Subject: SSD-4972, Four Points By Sheraton Hotel Expansion

Thank you for referring the above Development Application to the Heritage Branch for comment. As discussed, please receive the initial response from the Heritage Branch, under delegation from the NSW Heritage Council, to the proposed development. Having reviewed the proposed development the following comments are made:

Drawing Title
WEST ELEVATION

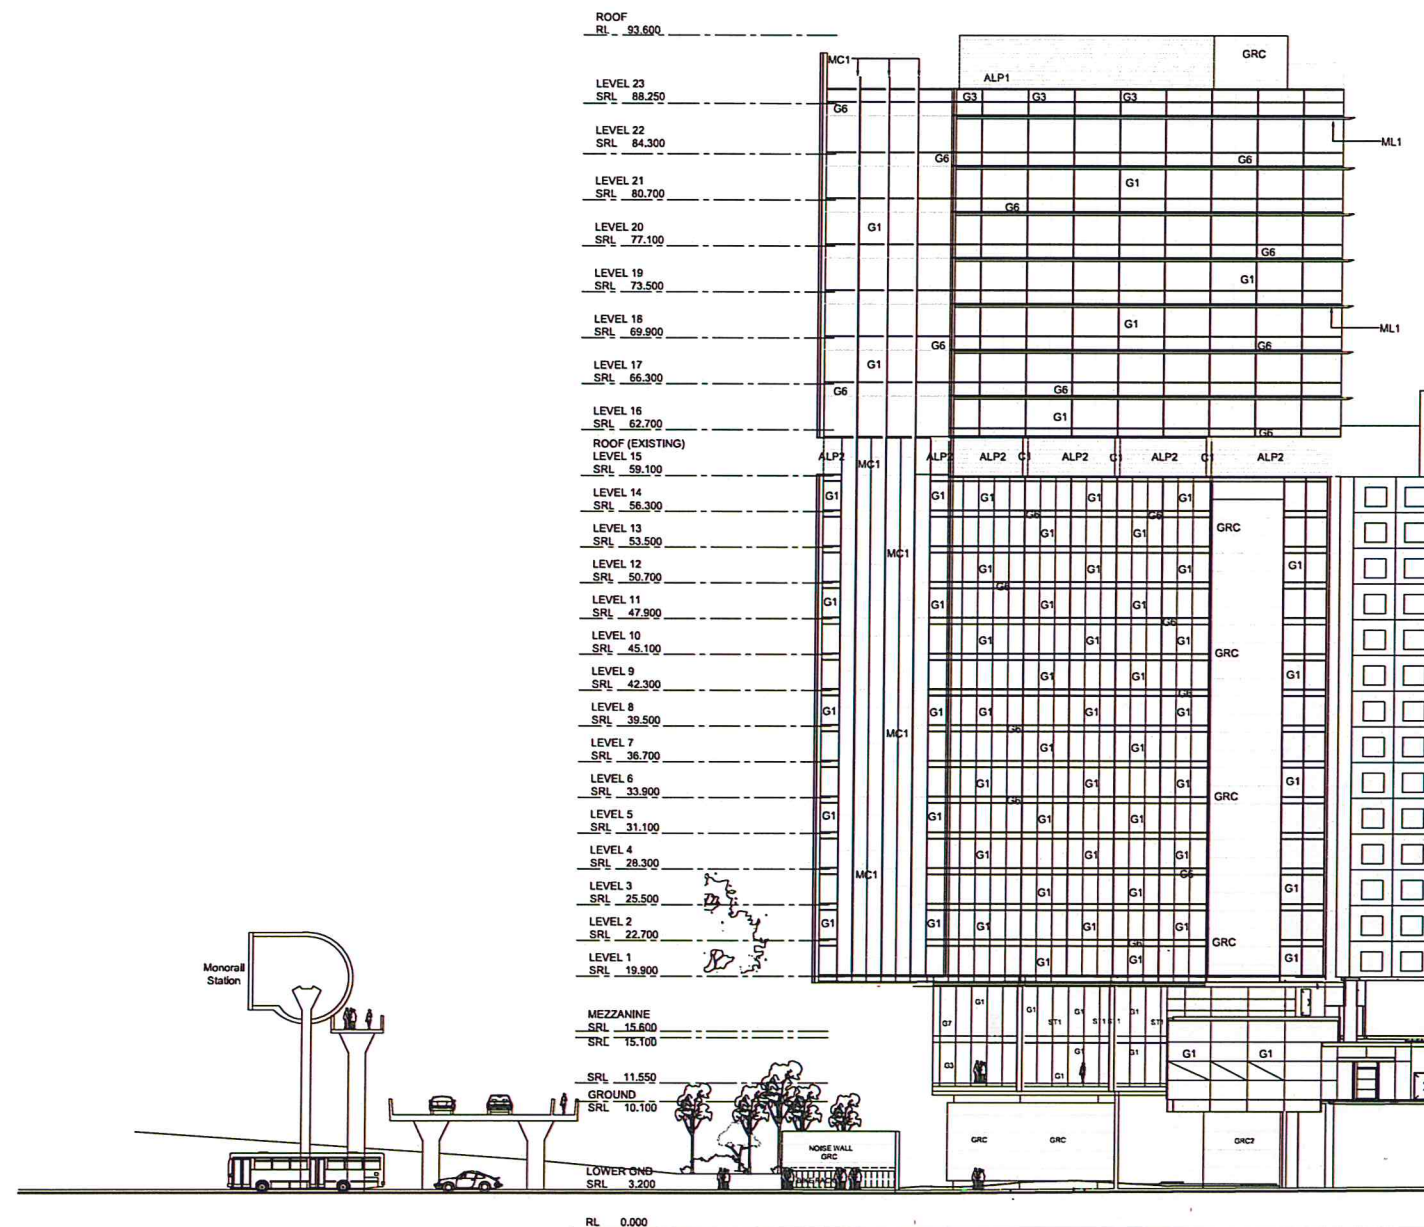
5. The Heritage Branch's primary concern is the tower's height and massing. The While any large scale building on this site is likely to have significant impacts on the setting of the Corn Exchange Building, a new building would reflect the context better if it were the same height as the existing hotel. The Heritage Branch suggests consideration be given to the Heritage Council's "Infill Guidelines" which may result in a more neutral, lower and calmer urban form.

The Heritage Branch also considers that separating the new tower and existing building either architecturally or physically would reduce the visual impacts by reducing the massing of the proposal. This could involve pulling the new tower away from the existing hotel.

6. The architecture of the façade read behind the Corn Exchange should also be given consideration. In particular, the relationship between the two facades.
